DRB Application No.: **04DRB-01091 (P&F)**

Project # **1003549**

Project Name: **ROSEMONT PARK ADDITION**

CITY OF ALBUQUERQUE  
PLANNING DEPARTMENT  
July 21, 2004  
Development Review Board  
Comments

PLAT OF
 LOTS 1-A & 1-B, BLOCK 1
 ROSEMONT PARK ADDITION
 SECTION 18, T. 10 N., R. 3 E., N.M.P.M.
 CITY OF ALBUQUERQUE
 BERNALILLO COUNTY, NEW MEXICO
 JULY 2004
 SHEET 2 OF 2

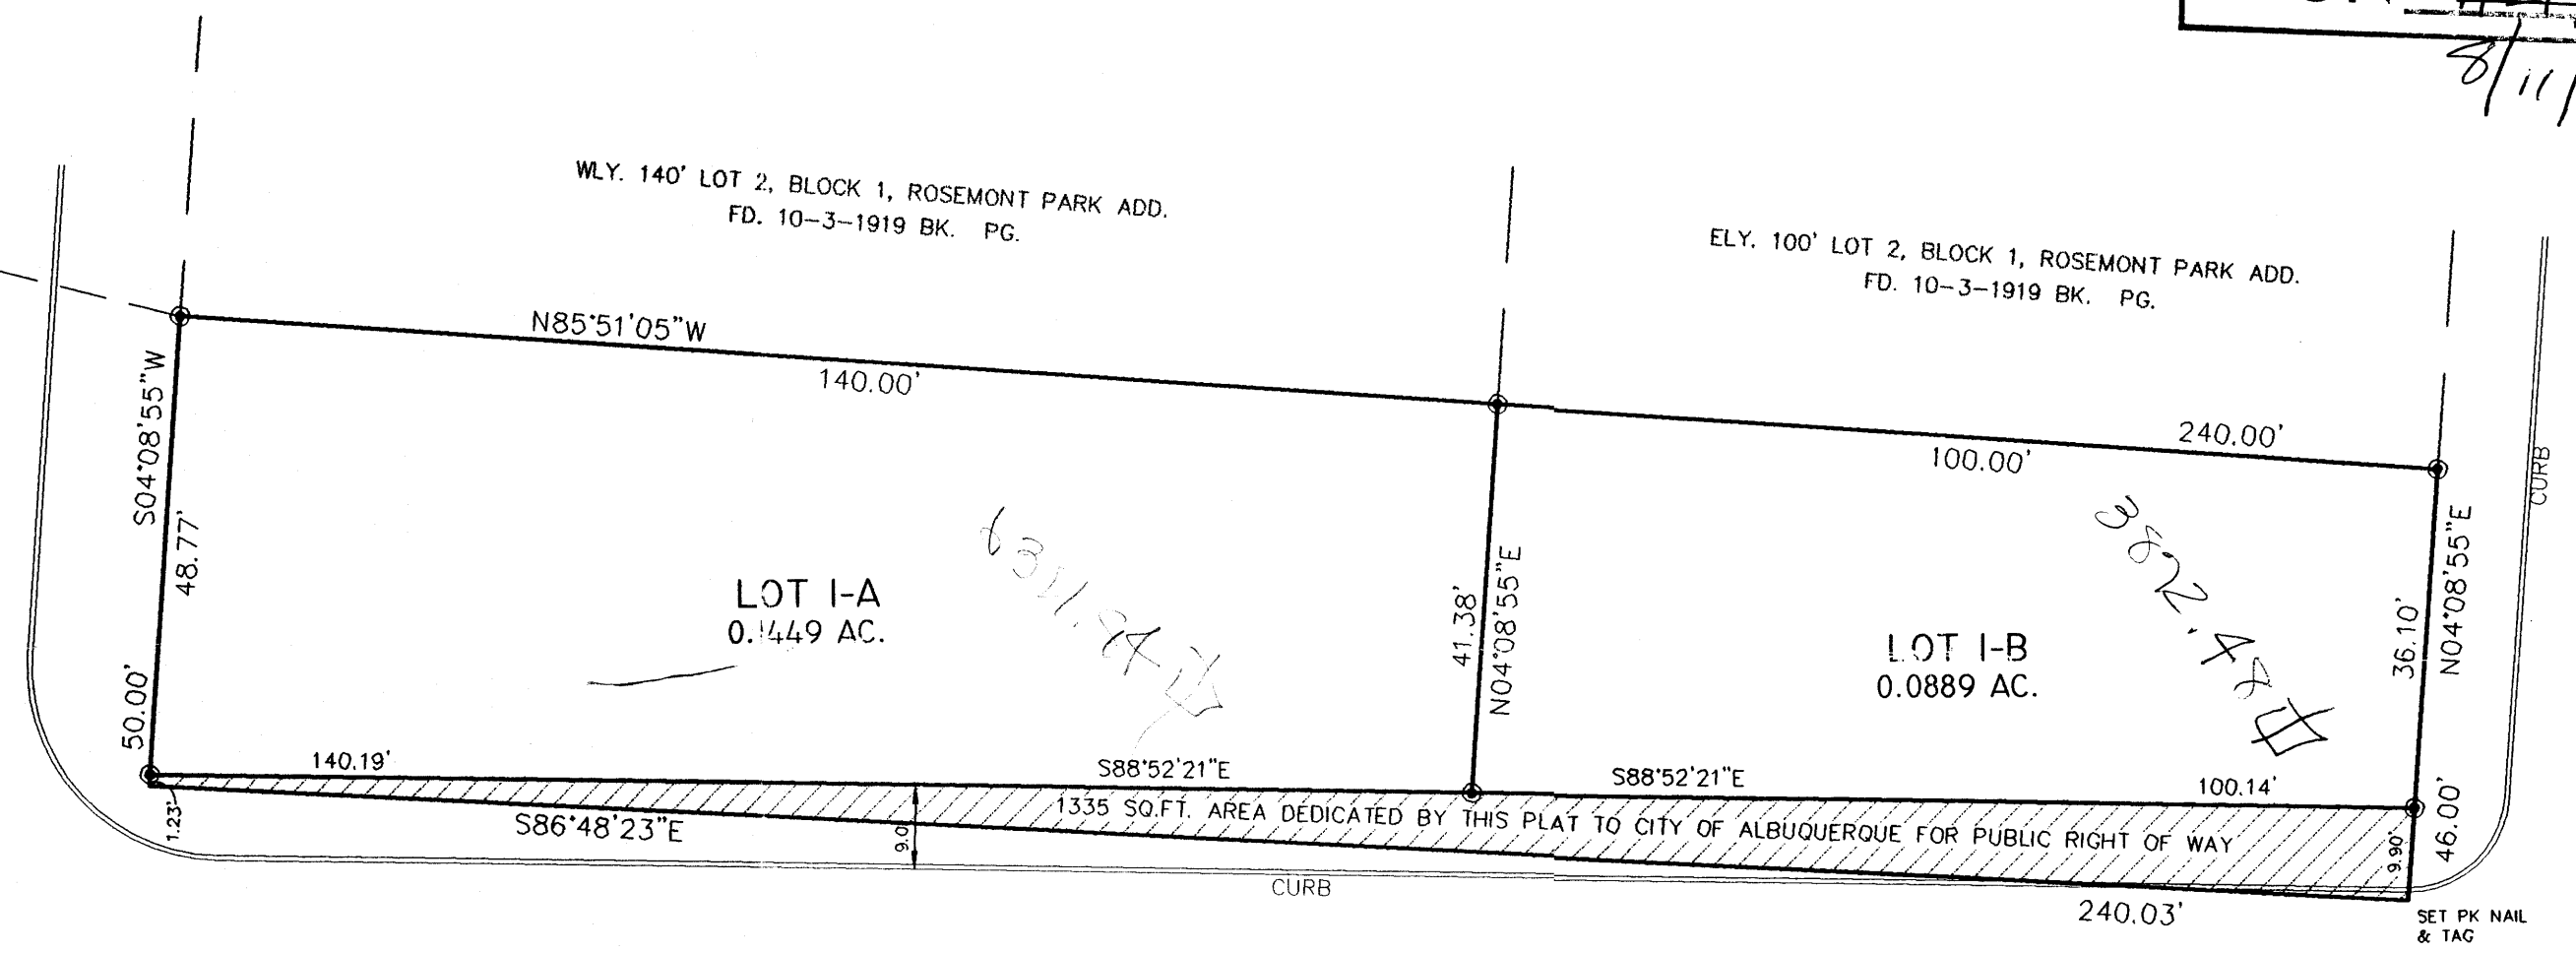
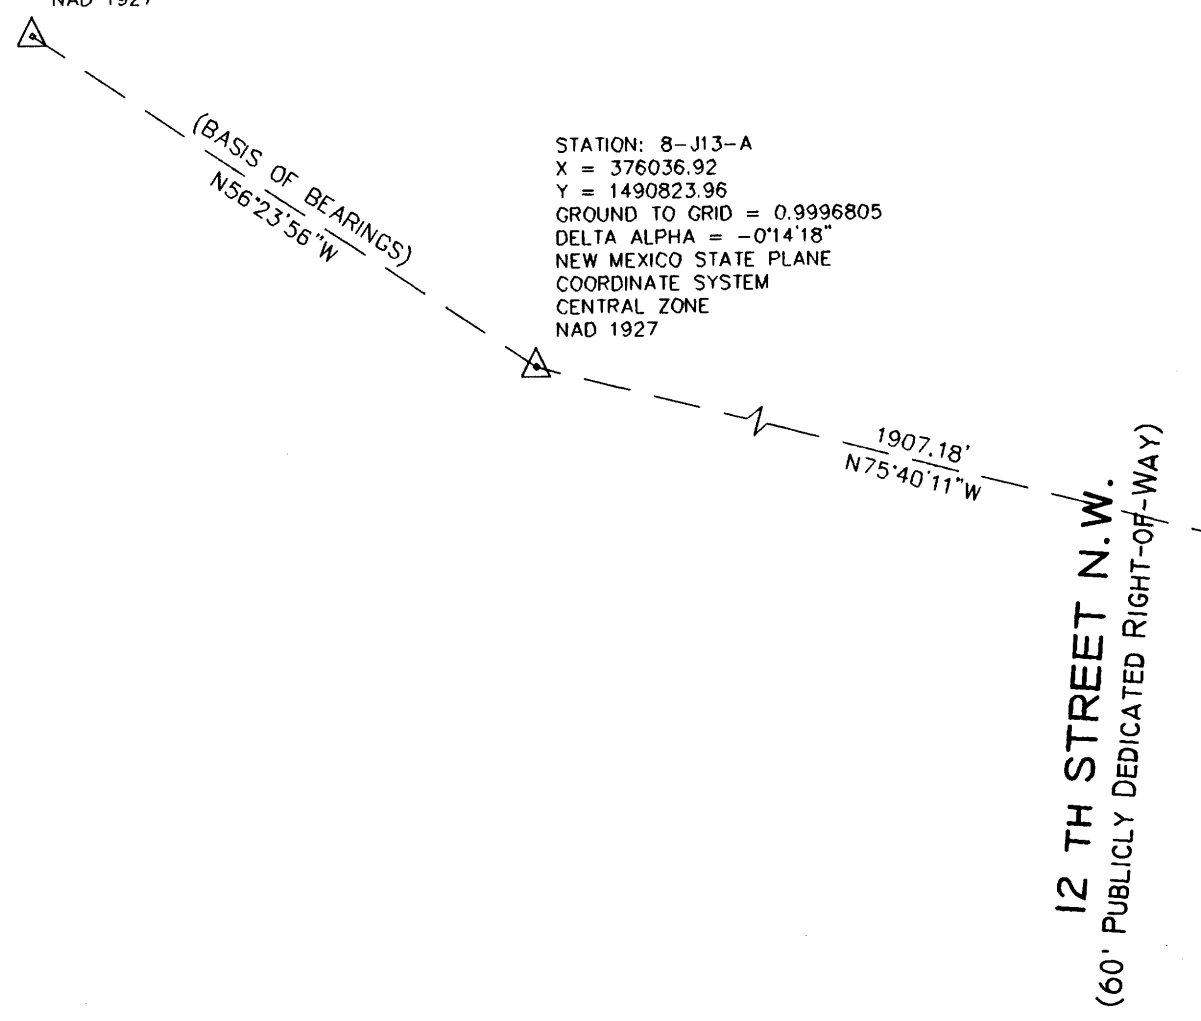
<u>No.</u>	<u>Comment</u>
1)	Sidewalk needs to be placed or guaranteed through the SIA process. (ie. Pre-plat with infrastructure list)
2)	Radius dedications need to be made at corners.

Current zoning is required on the plat under Subdivision Data.
